Our Ref: WA/33/18/OUT

Development Outline application with some matters reserved for the demolition of existing dwelling & erection of 5 No. dwellings. This application is a Departure from the Development Plan.

Location Spindlewood Yapton Lane Walberton

Proposed Block Plan Amend

Drawing.  
Proposed House I  
Plans

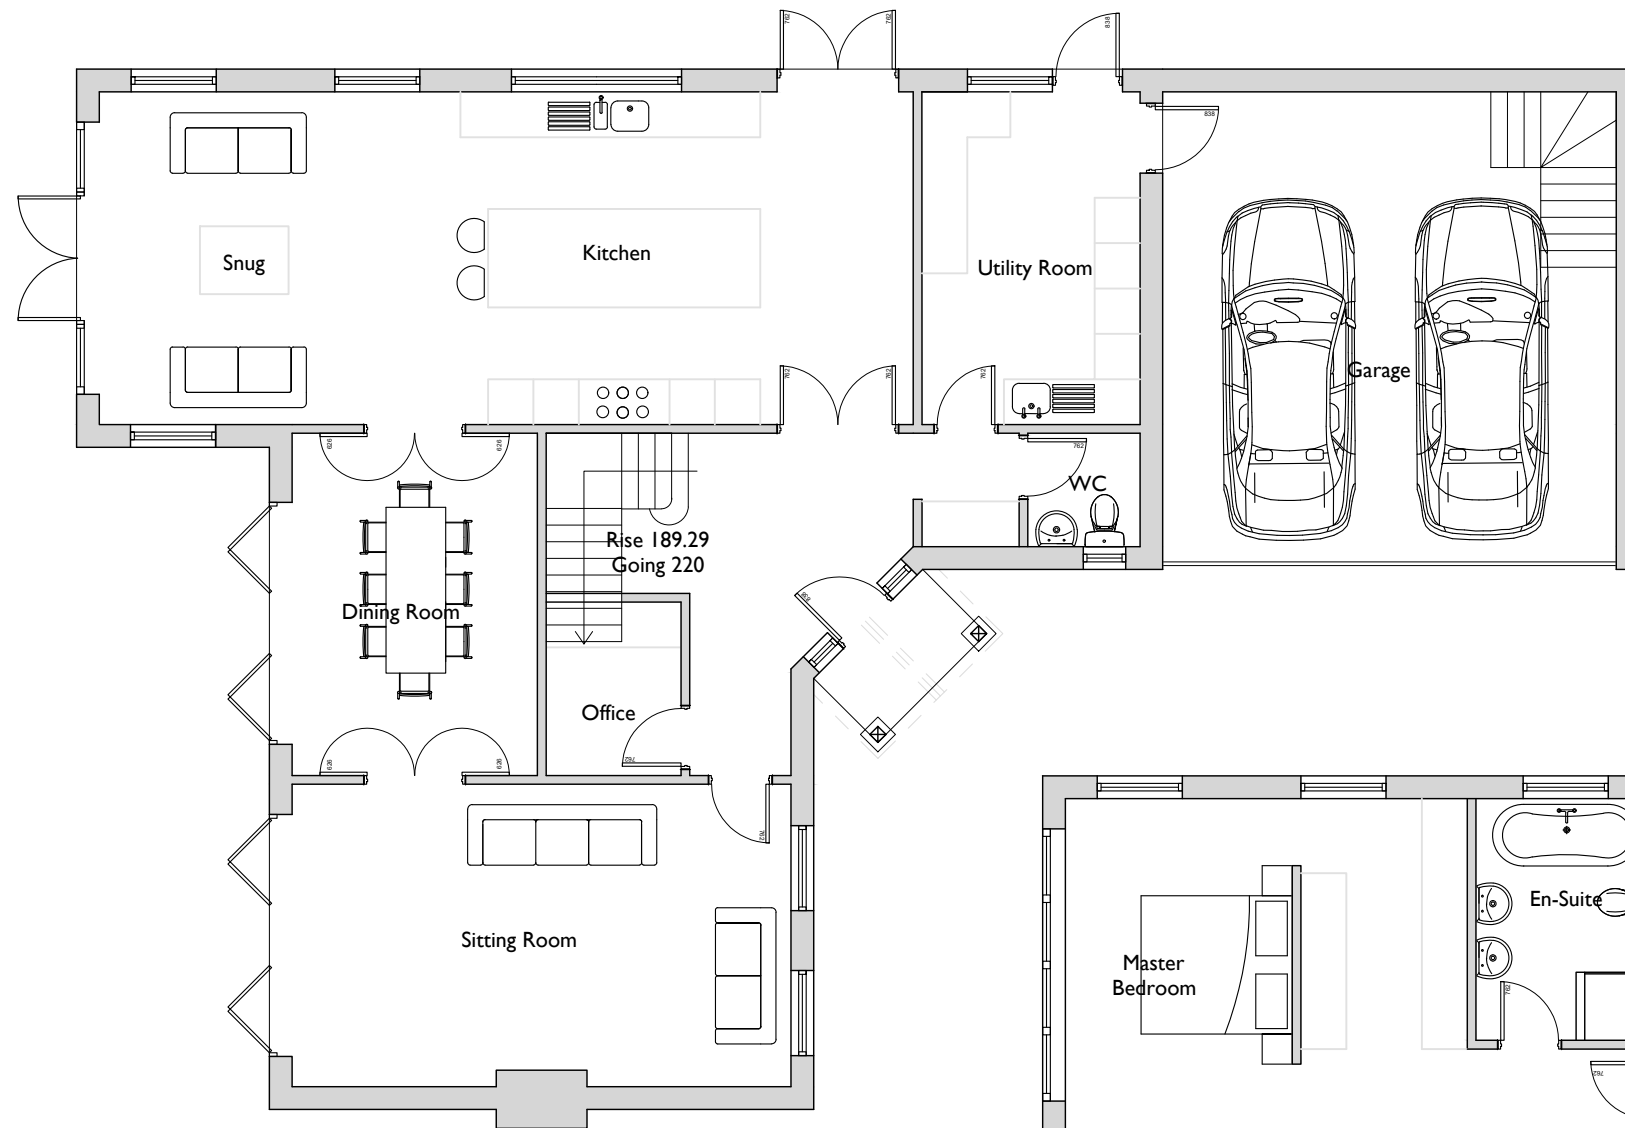
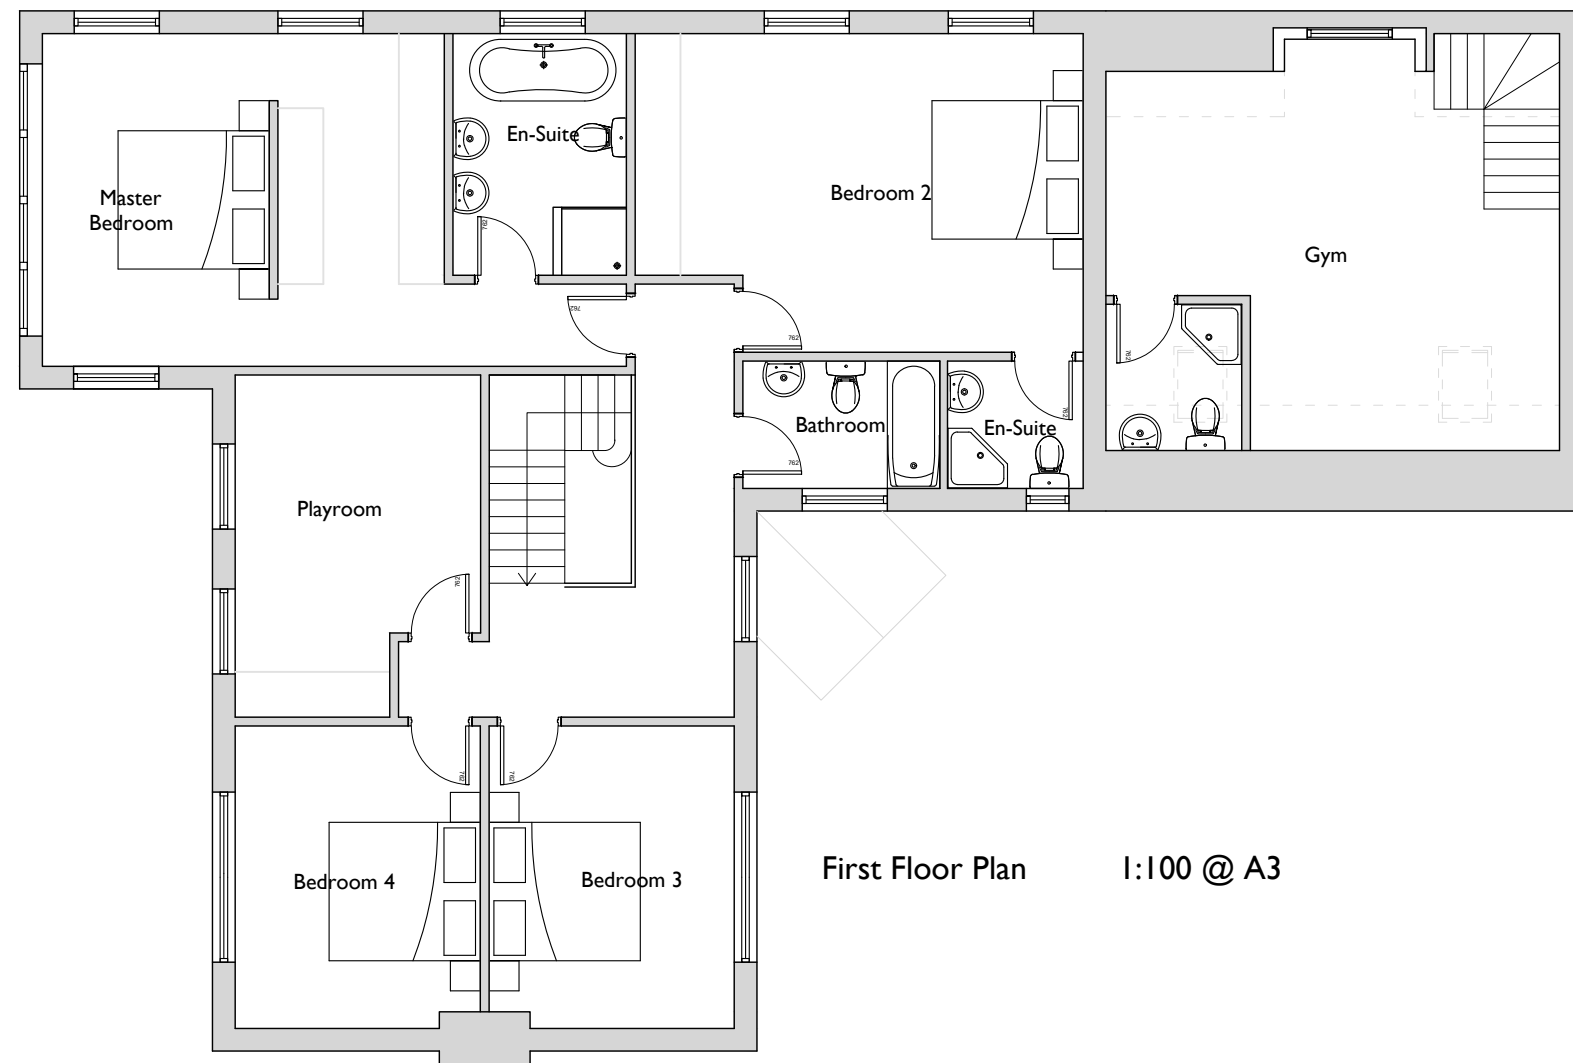
For house type 1, please show the velux on the first floor plan.

Drawing.
Proposed House 4 & 5
Plans

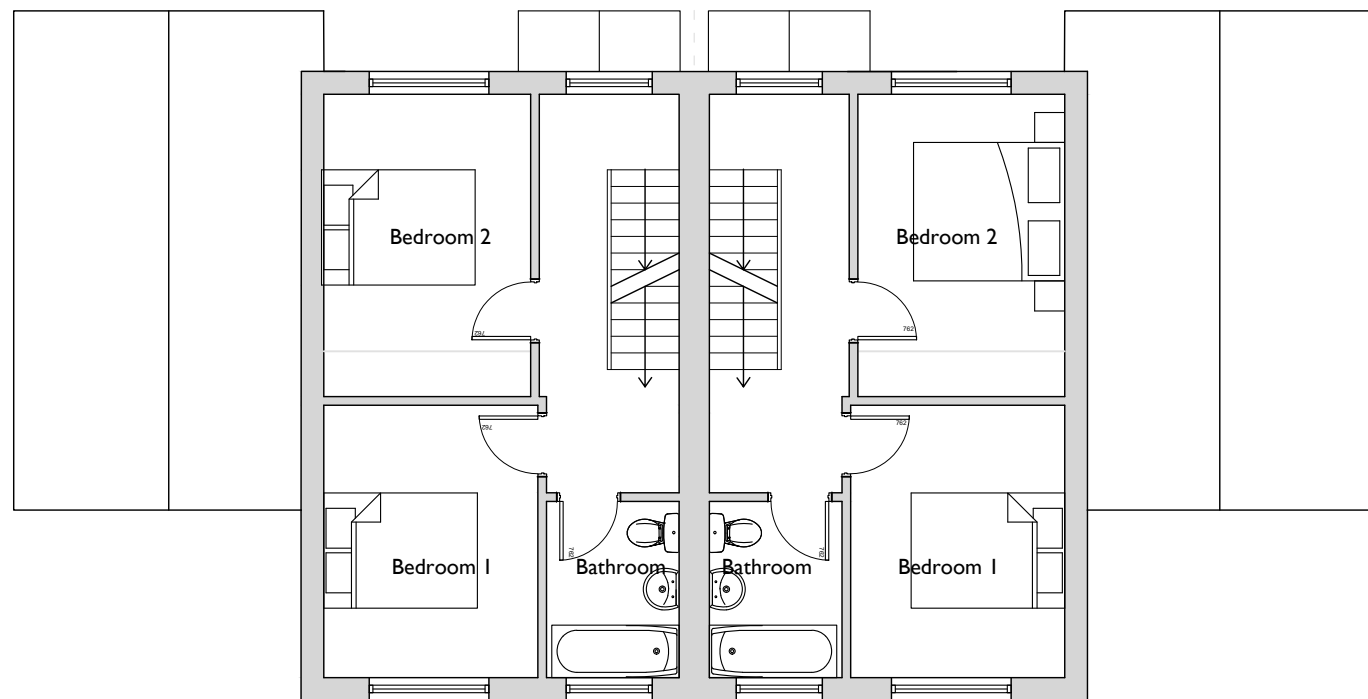
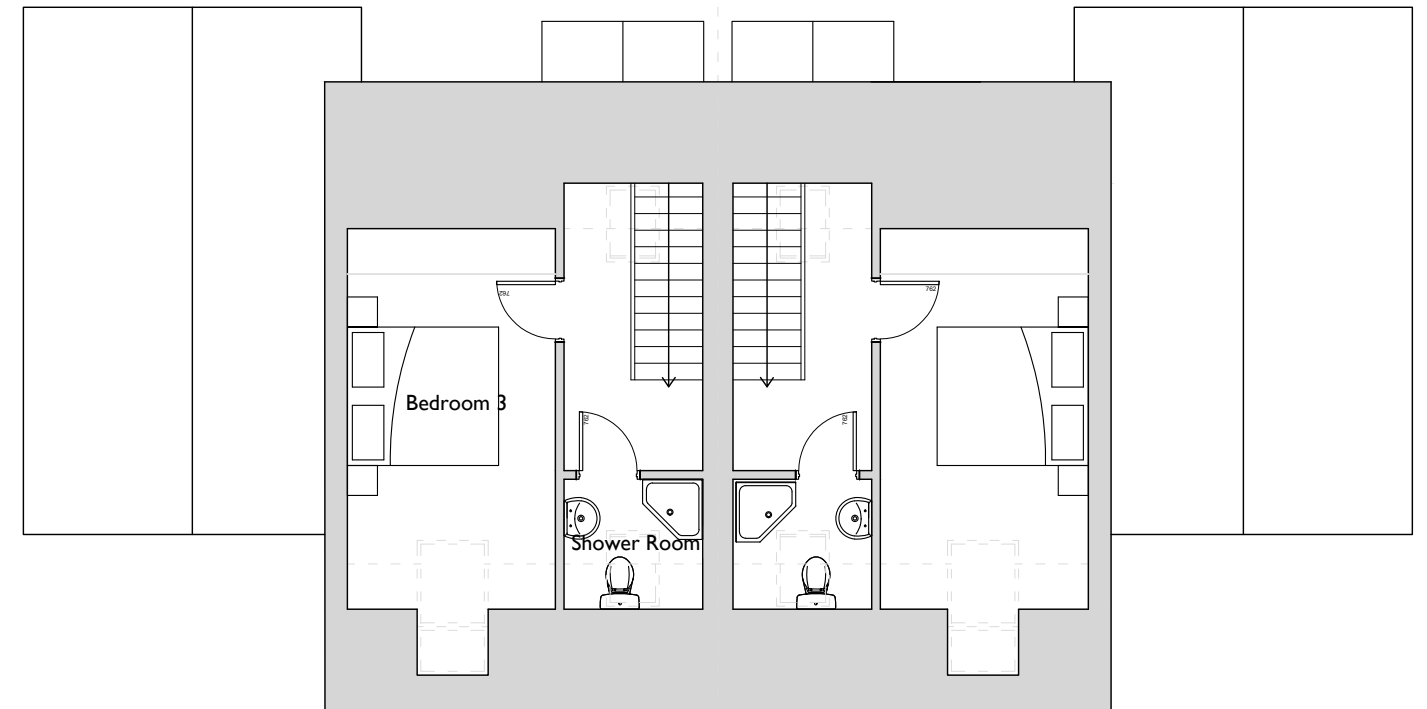
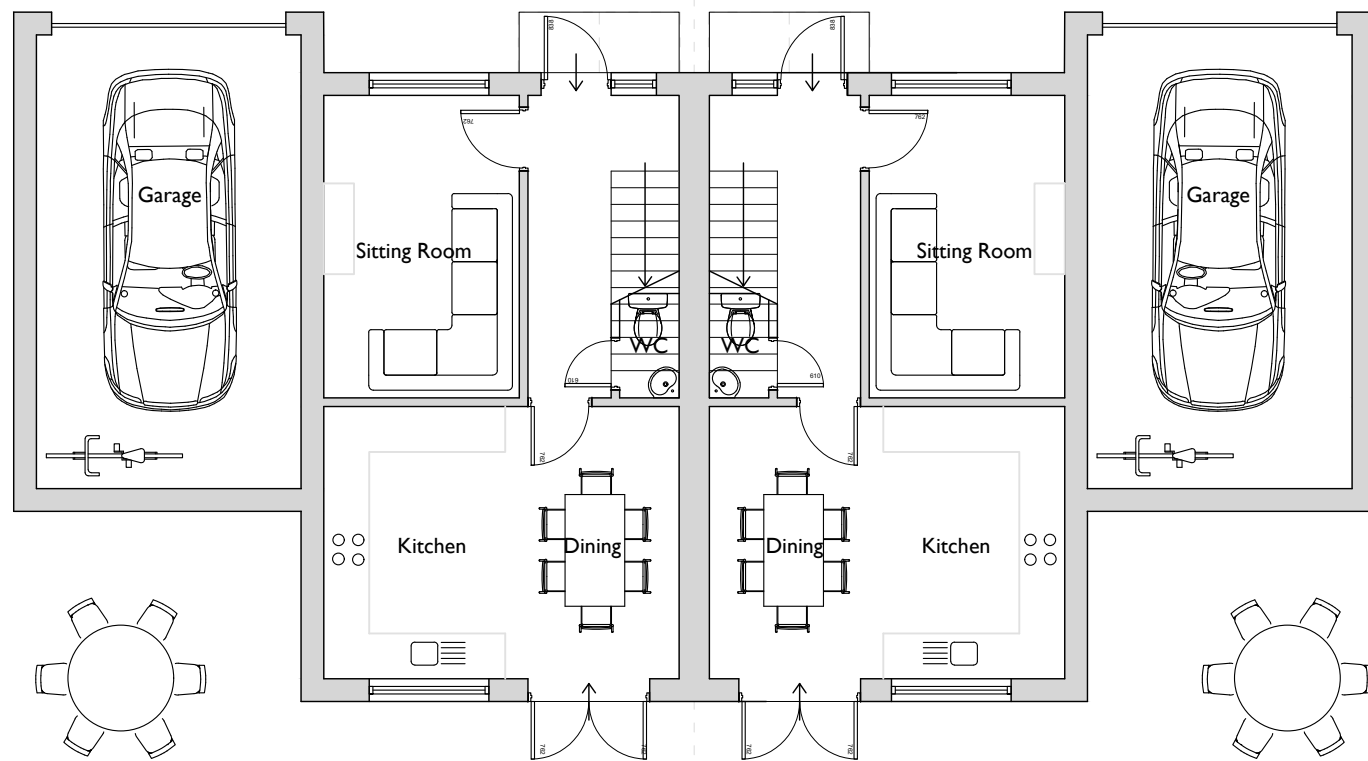
For house types 4 & 5, please show the velux on the second floor plan.

Drawing.
Proposed Site Plan
showing Swept Path Path
and Parking Provision

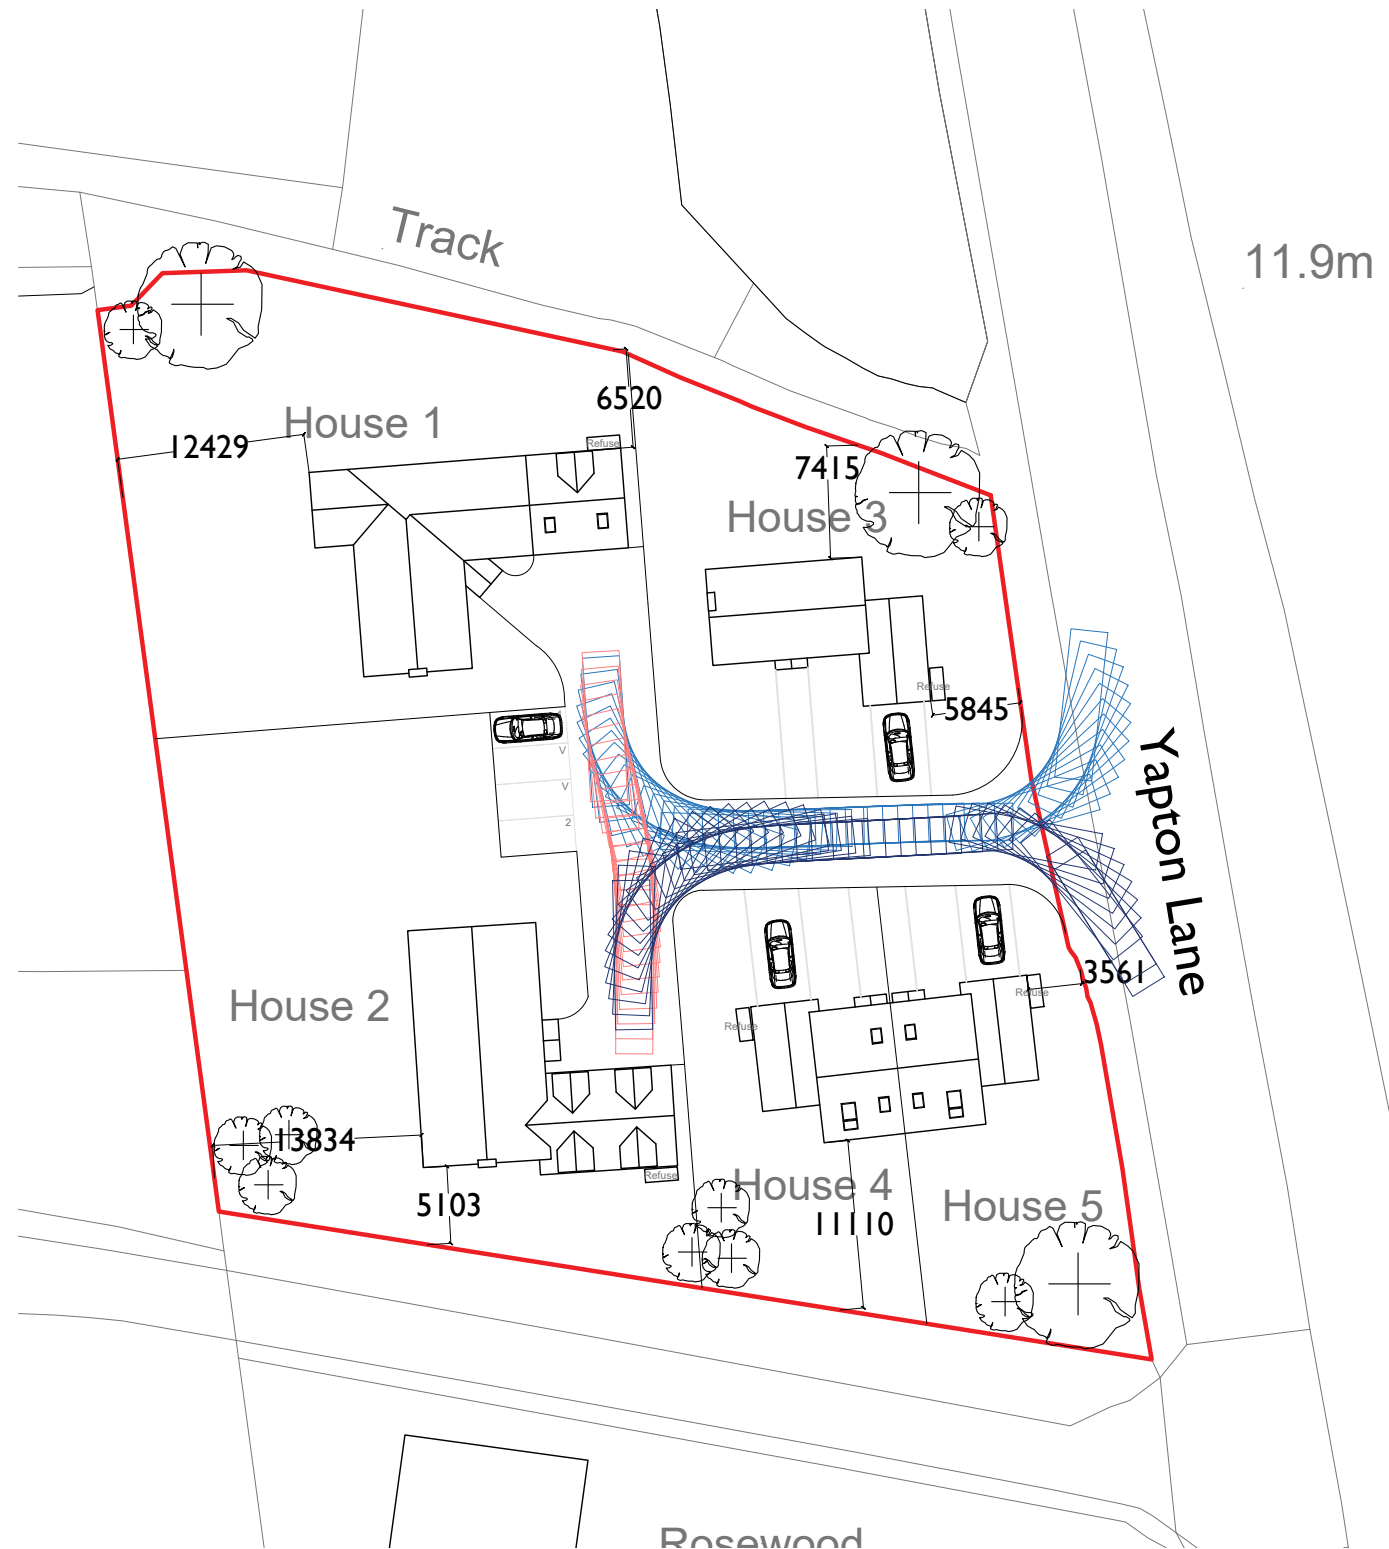
Please submit 1 electronic or 3 paper copies of a block/site plan at a scale of 1:500 or 1:200. Further details of what must be included on the plan can be found in the National Validation Requirements. Please provide measurements from the proposal to the site boundaries.
